Project:	Proposed Mosque and Madrasa, Healey Lane, Batley
Report title:	Stage 1 Road Safety Audit Response Report
Date:	07.10.2025
Document reference and revision:	21-382-007.02
Produced by:	Bryan G Hall
On behalf of:	Kirklees Council
Prepared by:	
Name:	Daniel McLean
Position:	Senior Transport Consultant
Signed:	
Organisation:	Bryan G Hall
Date:	07.10.2025
Checked By:	
Name:	Geoff Bowman
Position:	Consultant
Signed:	
Organisation:	Bryan G Hall
Date:	07.10.2025
Approved By:	
Name:	Nick Calder
Position:	Principal Engineer
Signed:	
Organisation:	Bryan G Hall
Date:	07.10.2025

This is the Response Report for the Stage 1 Road Safety Audit (ref: 25-117-001.02) dated 05.08.2025 for a proposed mosque and madrasa on the existing Healey Lane site.

**DRAWING REF:** 21185-D02-A **REV:**

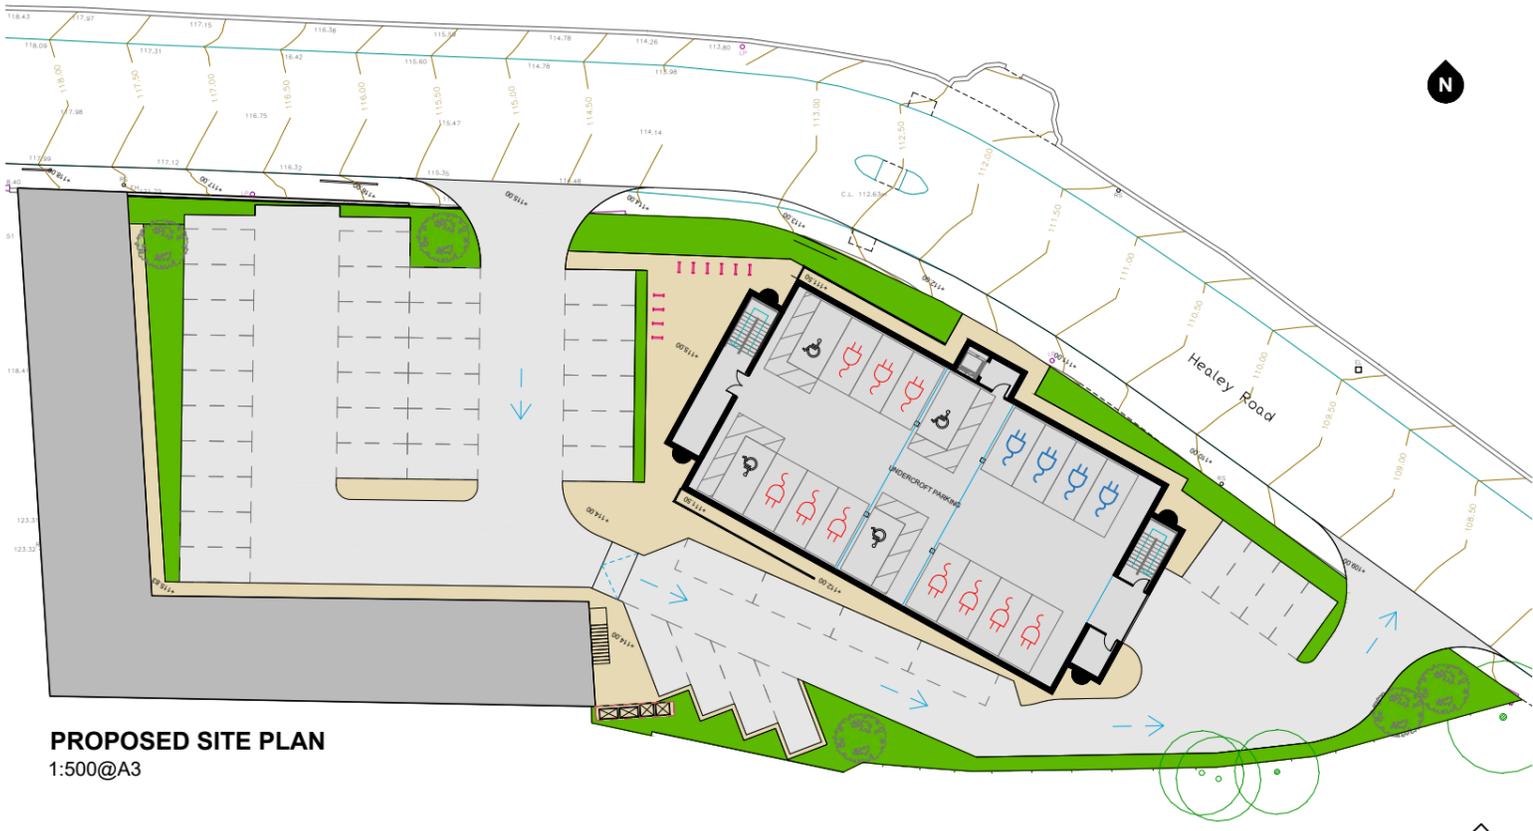
RSA Problem	RSA recommendation	Design organisation response	Overseeing Organisation response	Agreed RSA action
<p>A: Risk of collisions between vehicles waiting to turn right into the access from Healey Lane and vehicles travelling westbound.</p>	<p>Provide measures to ensure vehicles travelling westbound do not have to use the central hatching area when travelling around the bend or along the site frontage.</p> <p>Remove the on street disabled parking bays and implement 'no waiting at any time' restrictions on Healey Lane along the site frontage.</p>	<p>The updated site plan attached to this Response Report shows both on-street disabled bays are now to be removed. Four disabled bays will be provided within the site, which is an increase on the two currently being provided on Healey Lane.</p> <p>The updated site plan now also shows an extension of the recently implemented 'no waiting at any time' restrictions along the site frontage on Healey Lane.</p>

<p>B: Lack of pedestrian connection between footway on Healey Lane and building entrance at the second floor on the west elevation will lead to increased risk of conflict between pedestrians and vehicles at the access.</p>	<p>Provide safe pedestrian connection point between the Healey Lane footway to the west and the building entrance on the western elevation.</p>	<p>The site plan has been updated and shows steps immediately to the north of the western elevation of the building. These will be used by pedestrians accessing the proposed development from the west.</p> <p>Additional landscaping has been provided around the access to further restrict pedestrians accessing the site from this location.</p>		
<p>C: The level difference between the back of footway and the hardstanding around the building</p>	<p>Provide measures to reduce the risk of trips/falls at this location.</p>	<p>As part of the detailed design process appropriate measures will be considered and provided to</p>

presents a trip/fall hazard for pedestrians using Healy Lane.		reduce the risk of trips/falls at this location.		
D: Existing street lighting reduces the effective footway width close to the building entrance.	Relocate street lighting column.	As part of the detailed design process the position of the street lighting column will be reviewed and relocated if necessary in consultation with Kirklees Highways officers.		
E: Drivers failing to observe the one way system and attempting to leave or enter the wrong accesses.	Reduce the access widths and radii where feasible to reduce the risk of drivers misusing the one way system and provide an appropriate signage scheme.	It is not possible to reduce the access widths and radii as it would not be possible for a refuse vehicle to service the development. As part of the detailed design process, suitable road signs and road markings will be provided to reinforce the one-way system.

F: The pedestrian desire line between the two building is across a ramp leading to an increased risk of trip/falls.	Provide pedestrian crossing point away from the vehicle ramp.	The updated site plan shows that the ramp has been removed from the proposals and the pedestrian crossing point is to remain in the same location.		
G: Poor intervisibility between drivers entering and leaving the car park.	Provide a car park management system to warn drivers approaching the car park that a vehicle is leaving.	Vehicle speeds through the car park and around this bend will be very low. A car parking management plan will be implemented to effectively manage the car park. The client is content with this being secured via a condition.		
H: Risk of servicing vehicles undertaking reversing manoeuvres within the site.	Ensure servicing is managed to minimise the risk of reversing manoeuvres whilst pedestrians are present.	A servicing management plan will be provided. The client is content with this being conditioned.
